OFFICIAL NOTIFICATION OF DECISION

Project# PR-2020-004447
Application#
SI-2021-01885 SITE PLAN

For all or a portion of:
TRACT A-1, SUNPORT MUNICIPAL ADDITION
zoned **NR-SU**, located at **2200 SUNPORT BLVD**
SE between UNIVERSITY BLVD SE and YALE
BLVD SE containing approximately 20.88
acre(s). (M-15)

1. This is a request to construct a new electric substation.
 1. Pursuant to 6-6(l)(3) Review and Decision Criteria An application for a Site Plan – DRB shall be approved if it meets all of the following criteria:
 - a. 6-6(l)(3)(a) The Site Plan complies with all applicable provisions of this IDO, the DPM, other adopted City regulations, and any conditions specifically applied to development of the property in a prior permit or approval affecting the property.

3 SEWER CAP DETAIL
NOT TO SCALE

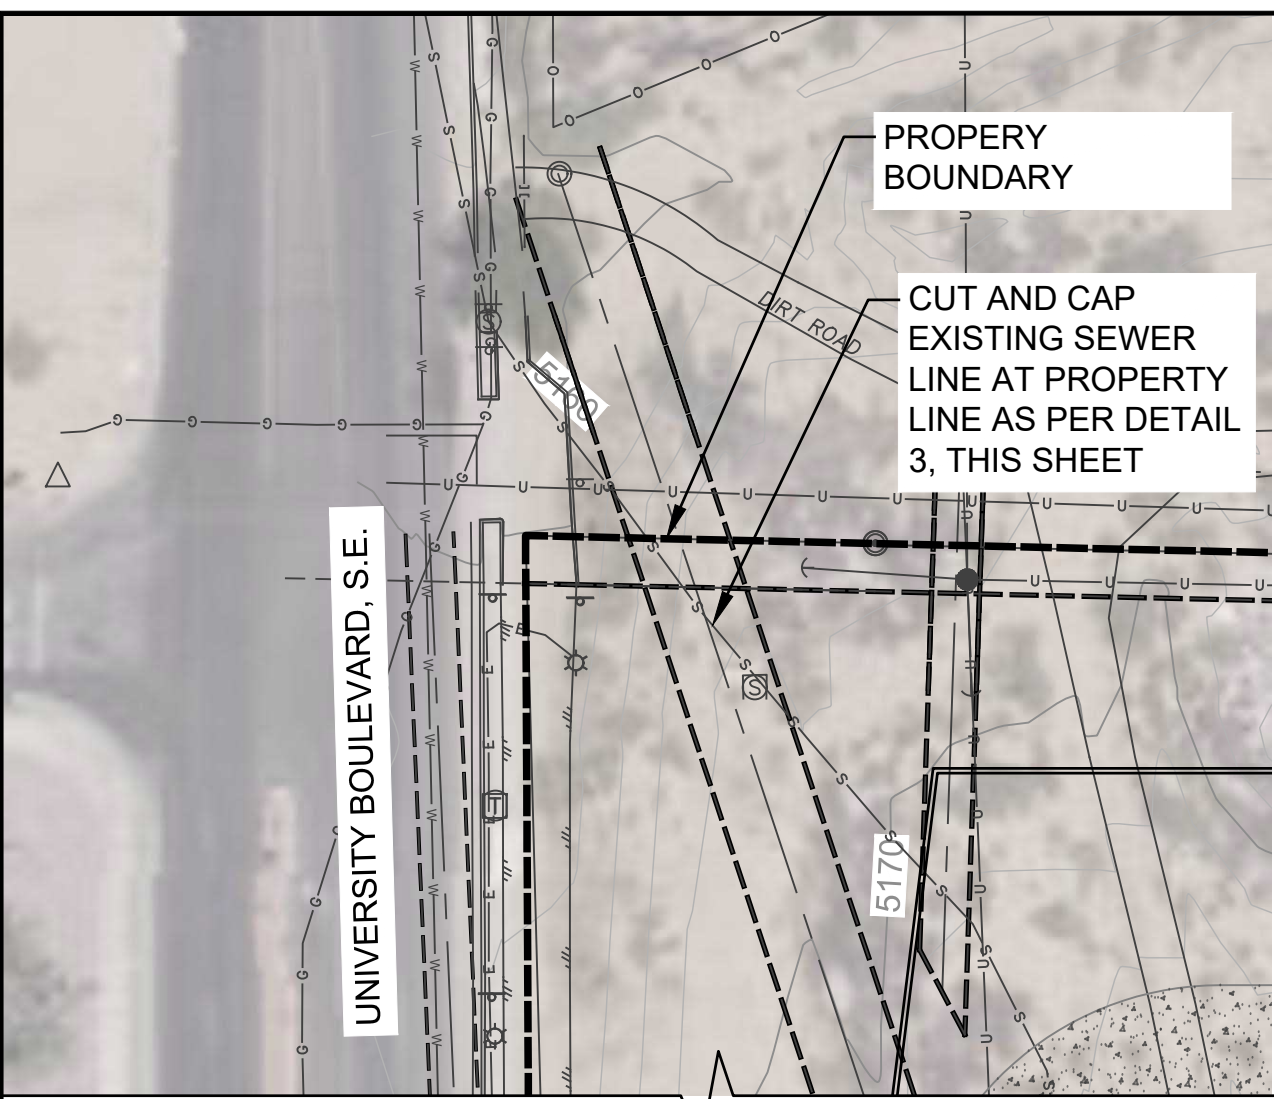
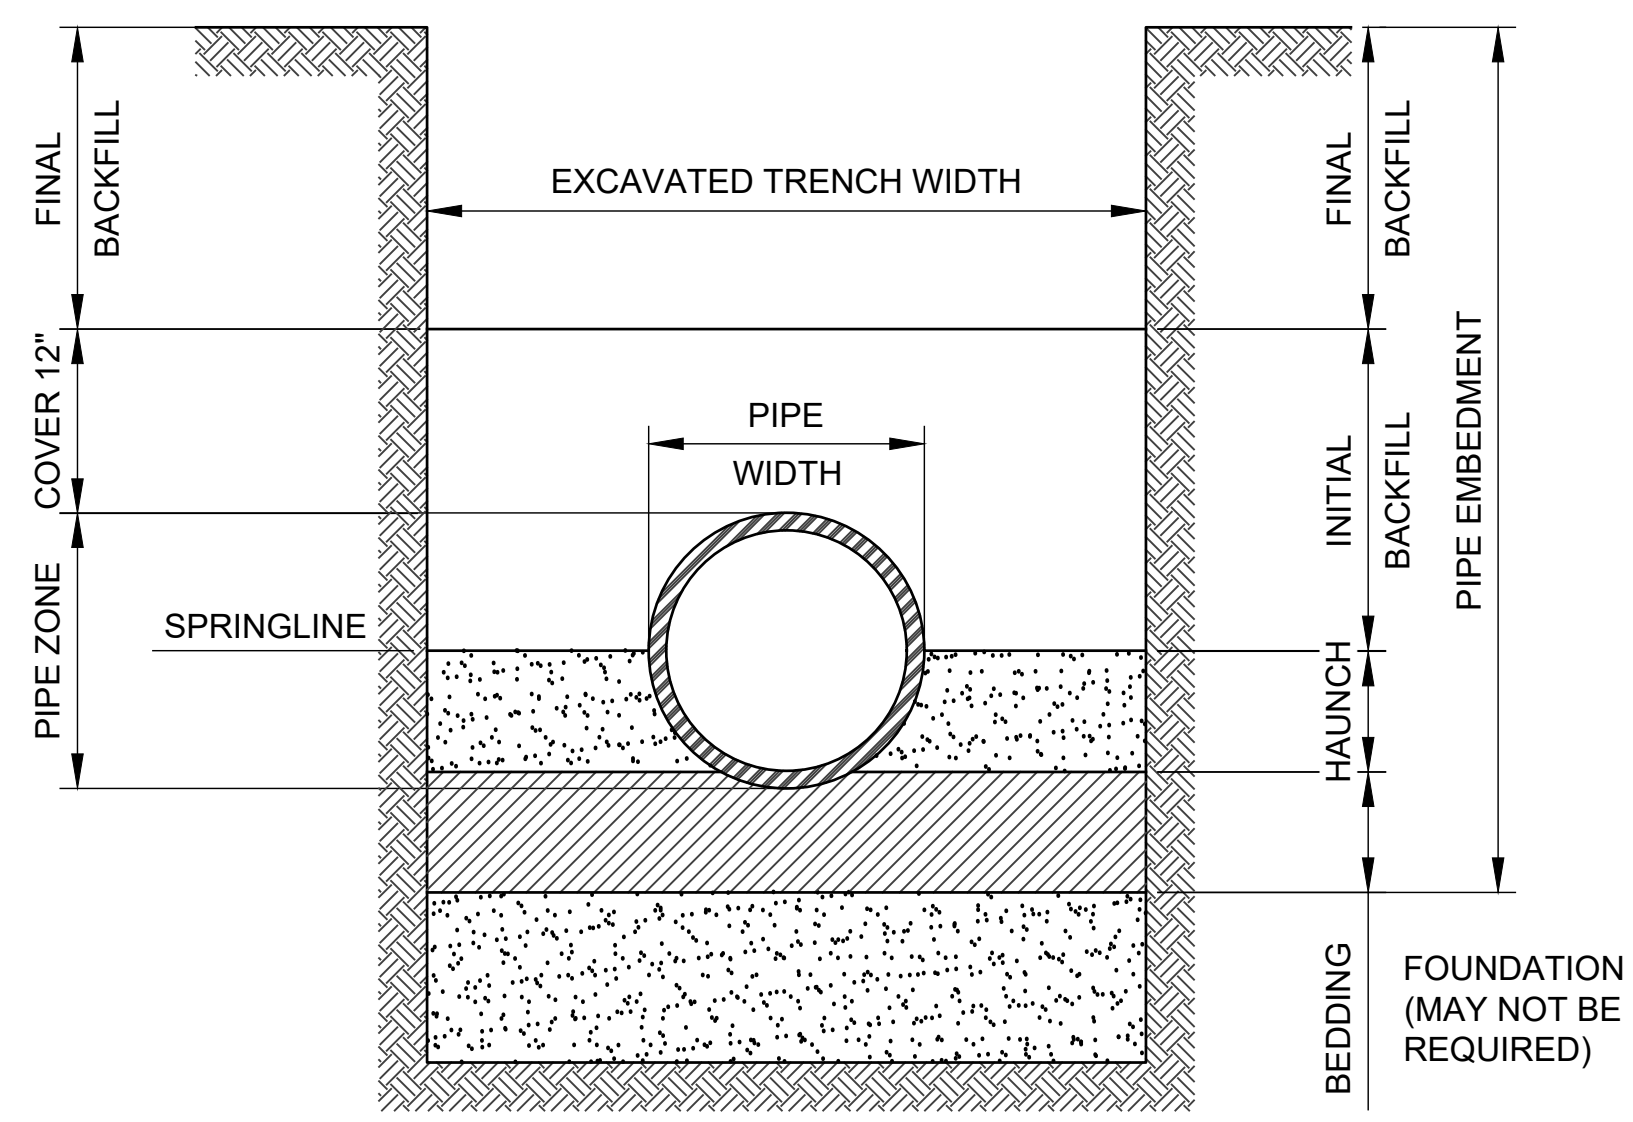
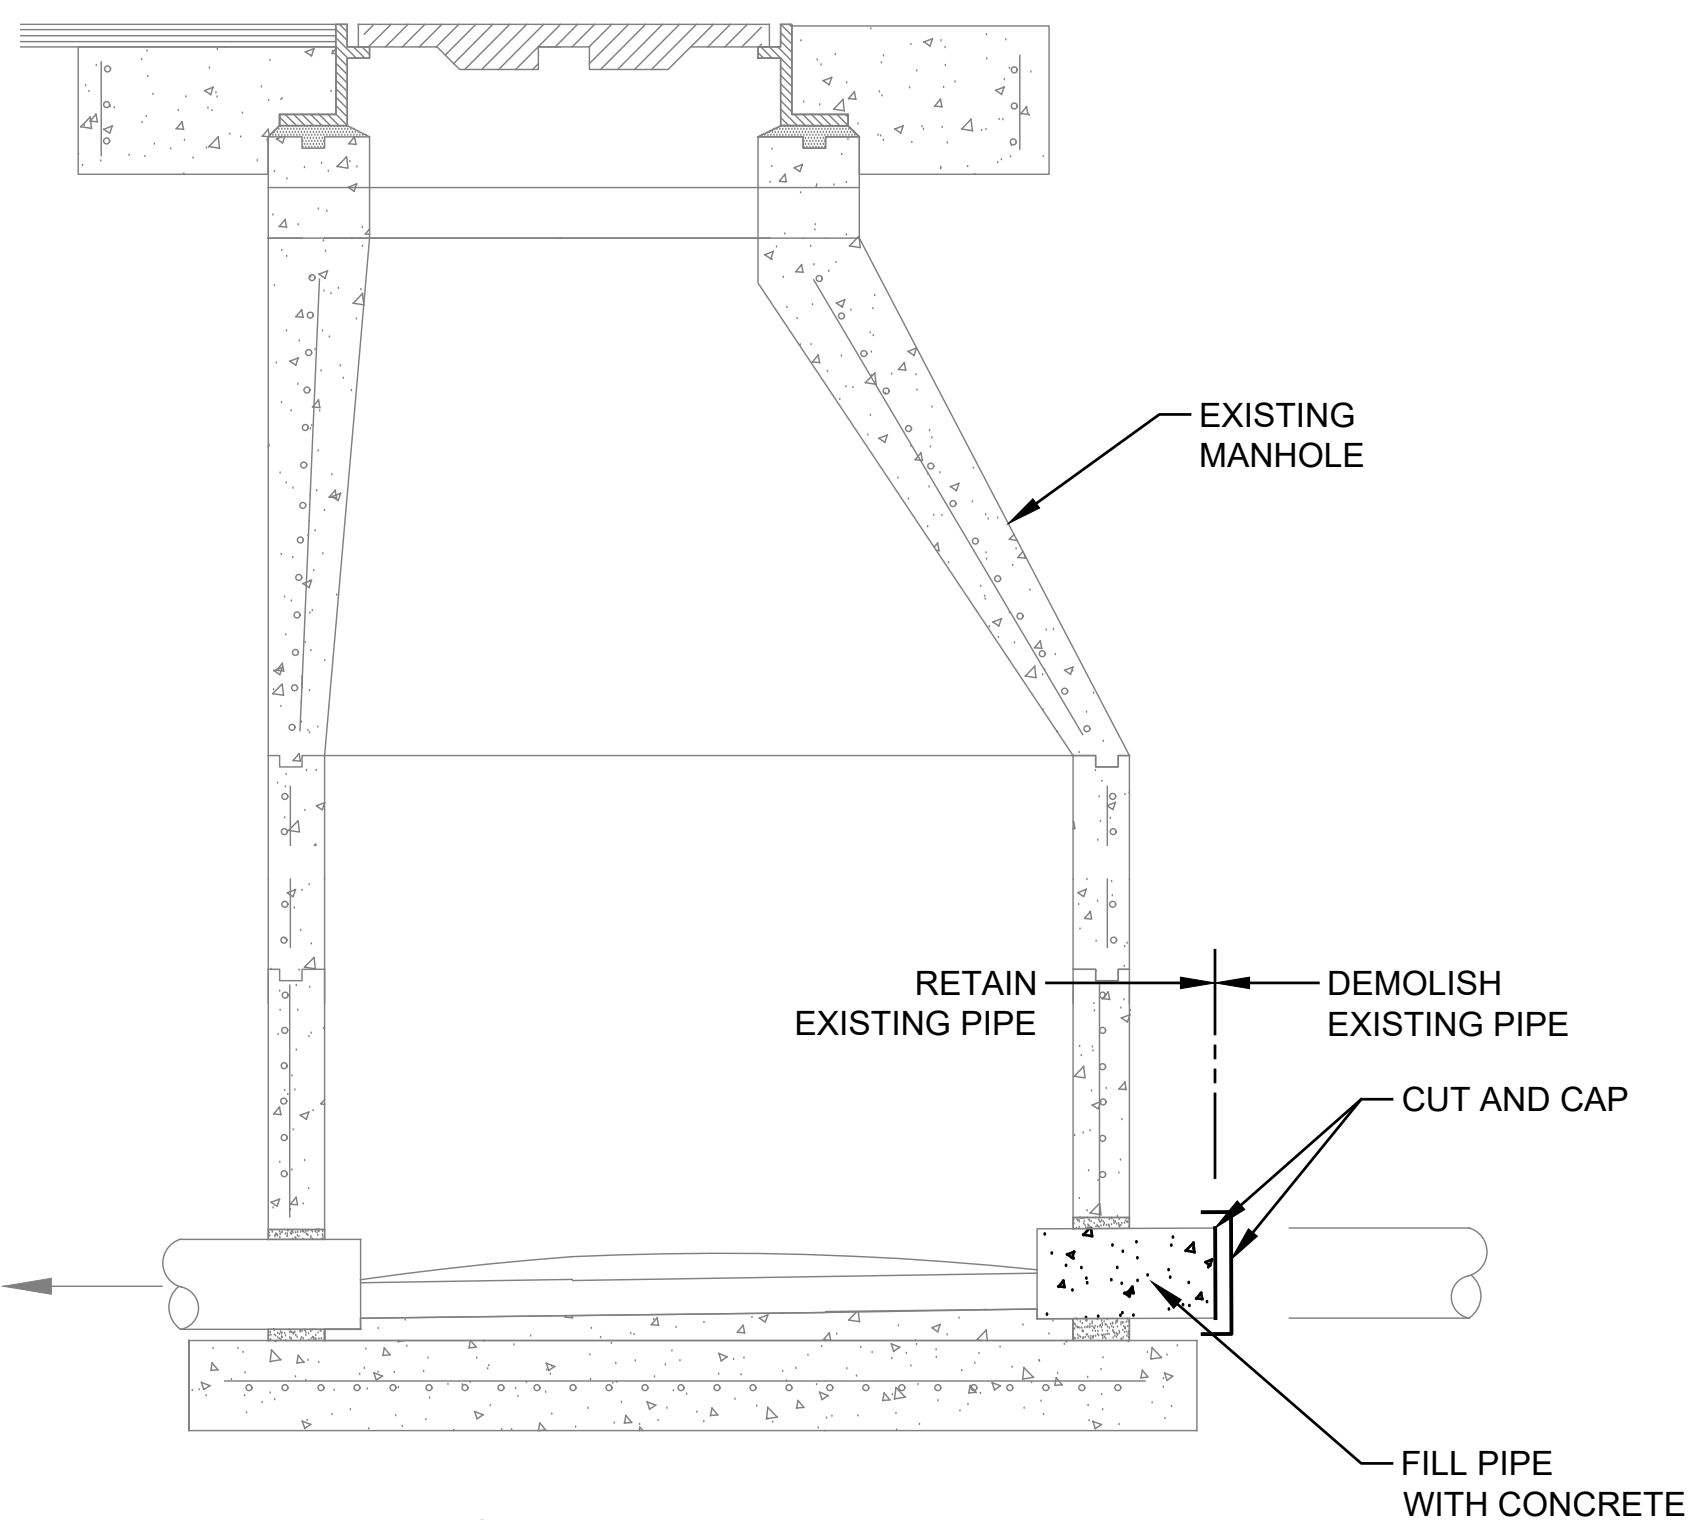
2. The applicant provided notice as required by 6-1-1 of the IDO.
3. A work order is required for the removal of the public sewer main on the site for which the irrigation meter shall be held until completion of the public sewer main removal.

1. This Site Plan is valid 7 years from DRB approval (12/8/2021). An extension may be requested prior to the expiration date.
2. Final sign off is delegated to ABCWUA for a paper easement for public sanitary sewer.

DR:	DATE: 02/01/21
CKD:	OK:
APP:	SCALE: As Noted
REV. NO.	SBD-7602-S6 6 OF 7

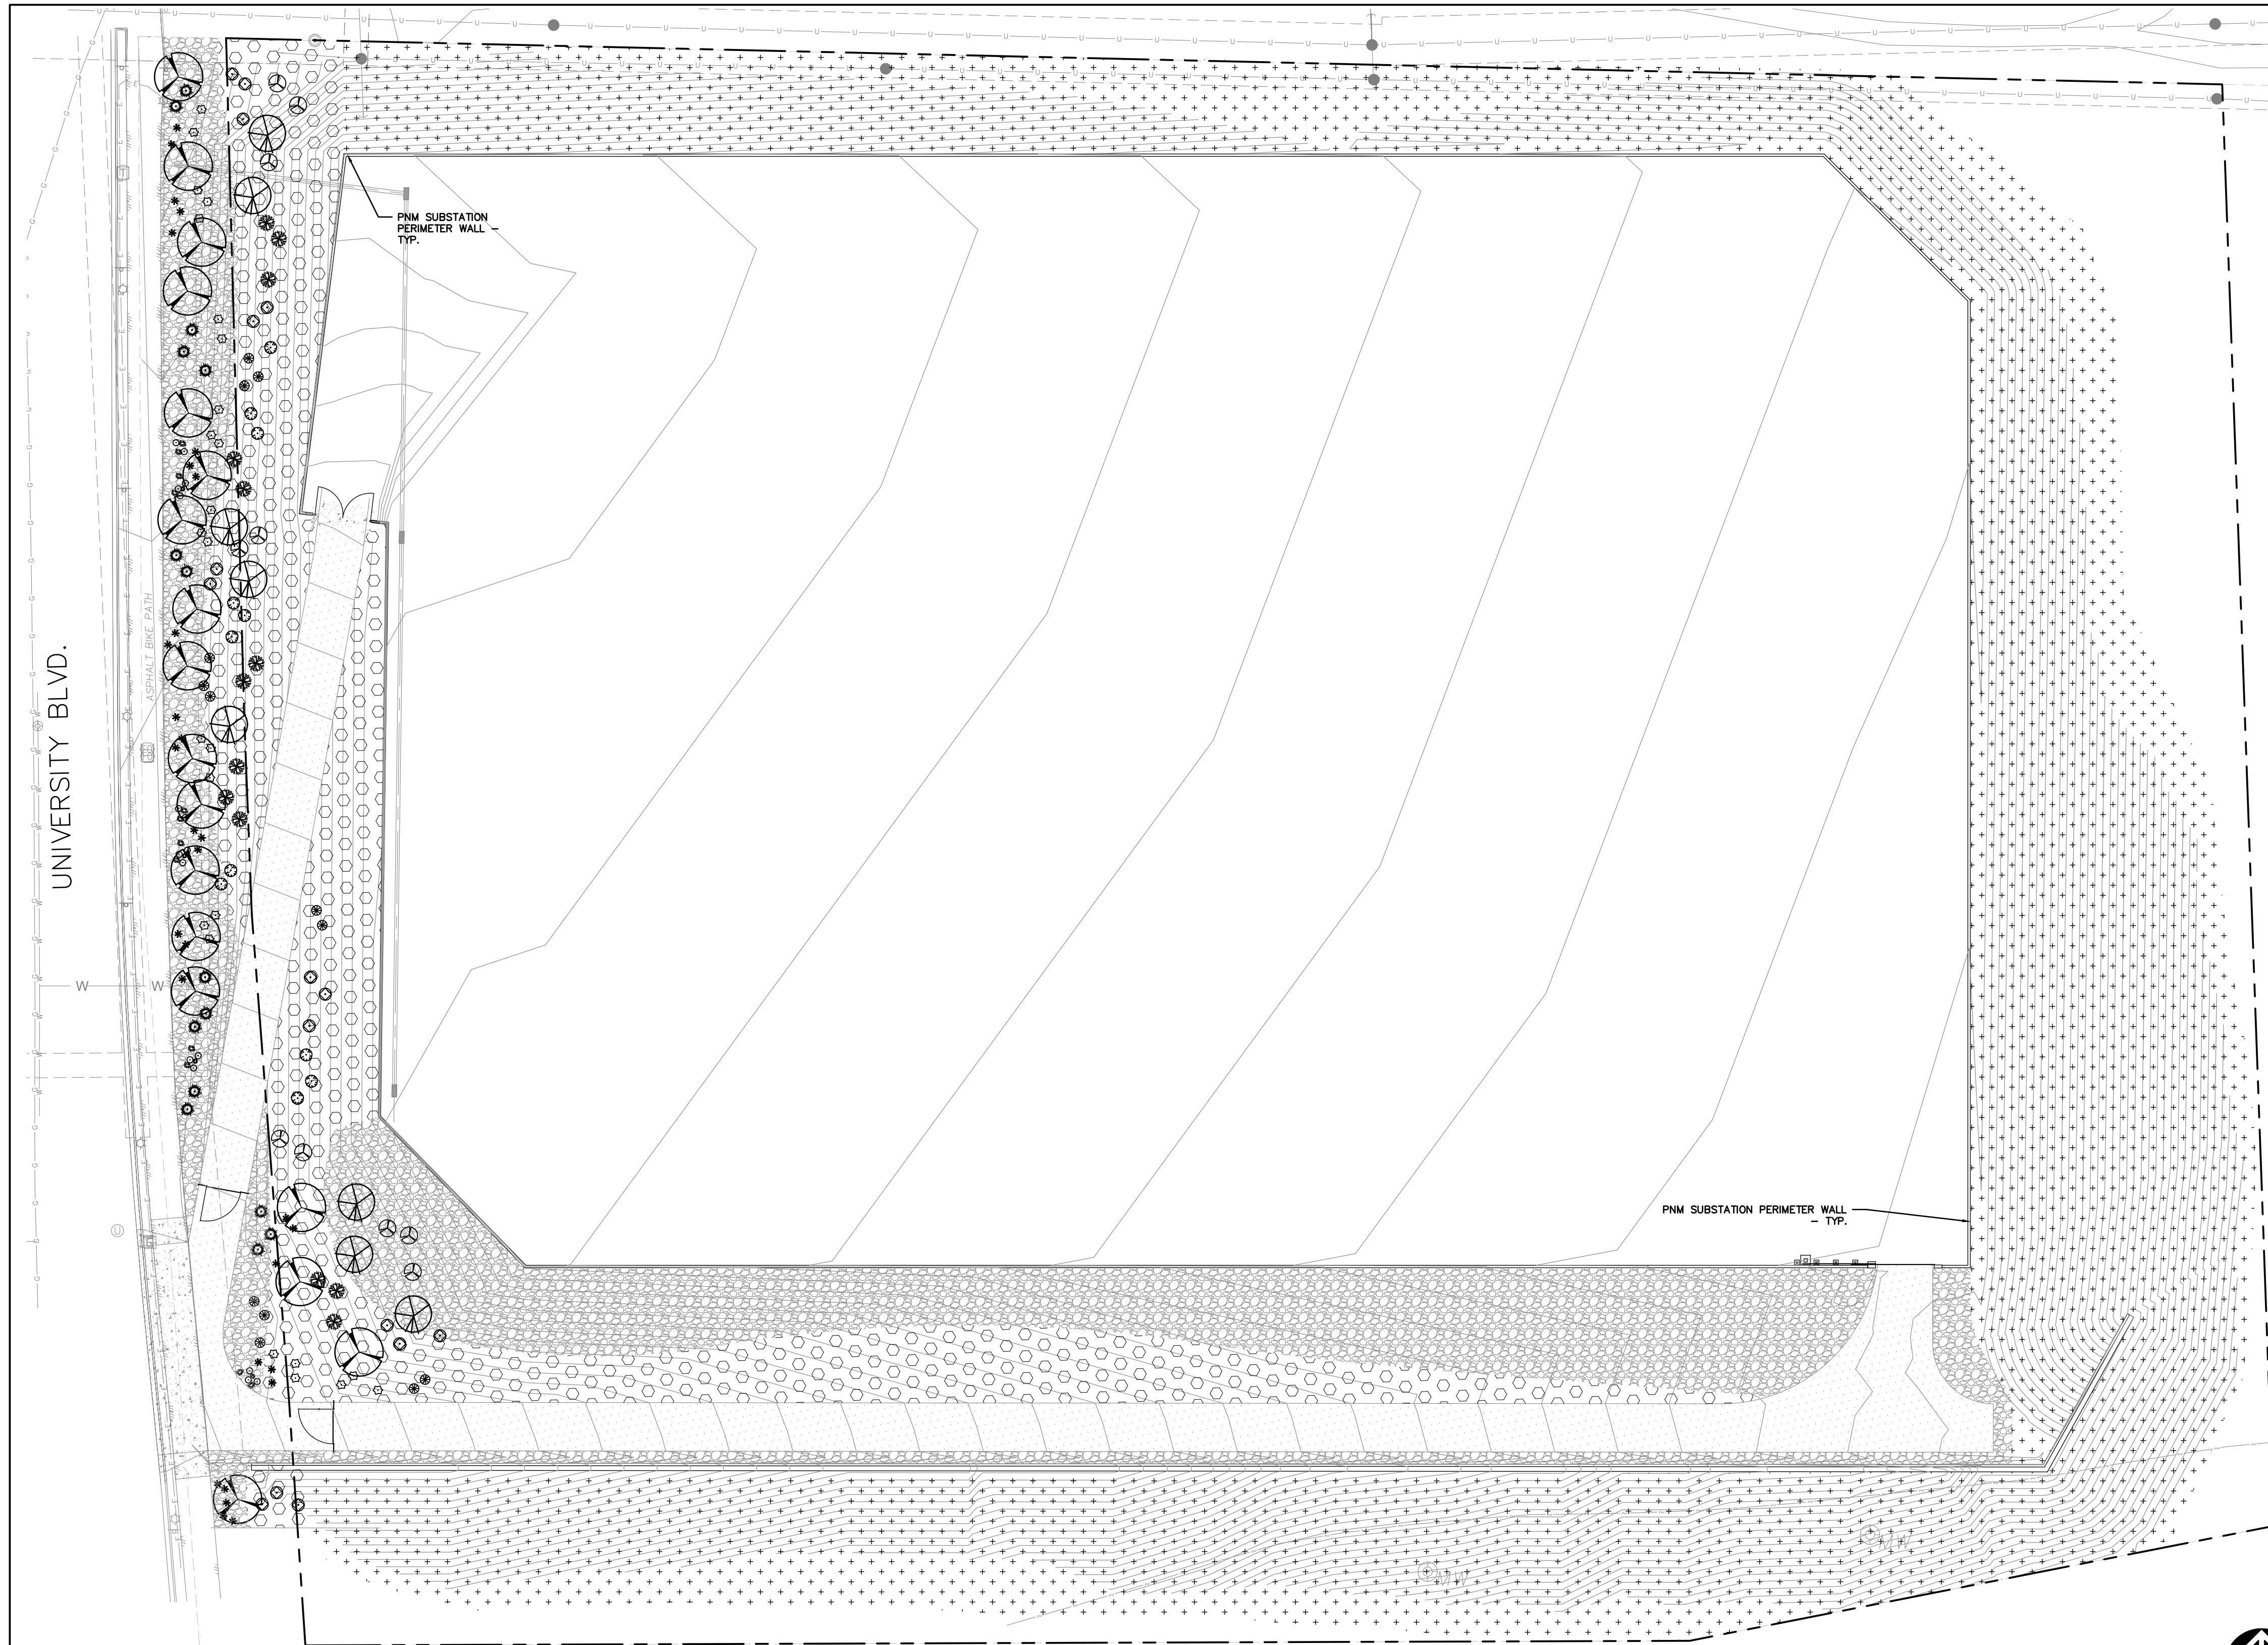
The proposed development complies with all applicable provisions of the IDO and DPM with the exception of the landscaping, buffering, and screening requirements of 5-6 of the IDO. An Alternative Landscape Plan will be required to be approved administratively by City staff which is consistent with the purposes of 5-6 of the IDO; the Alternative Landscape Plan must not include a reduction of tree planting requirements;

the Alternative Landscape Plan must provide equal or superior buffering of adjacent properties from anticipated impacts of the proposed development; the Alternative Landscape Plan must provide equal or superior visual appearance of the property when viewed from the street; and the Alternative Landscape Plan must provide equal or superior carbon dioxide absorption and heat island reductions.

3. Final sign off is delegated to Planning for a signature block for DRB and Environmental Health signatures; Environmental Health signature; project and application numbers to be added to the Site Plan; Alternative Landscape Plan approval; turnarounds to be provided in front of the University Boulevard gates; minor notes for the driveway detail as discussed at the December 8, 2021 hearing; add a landscape note to require a minimum of 5-feet of clearance from the trail to any plant material; submit PNM property easement to the City of Albuquerque Parks and Recreation Department (PRD) for review and possible update to allow for PRD access to the trail for maintenance into perpetuity; and for the Site Plan sheets to be signed and sealed by a licensed design professional.
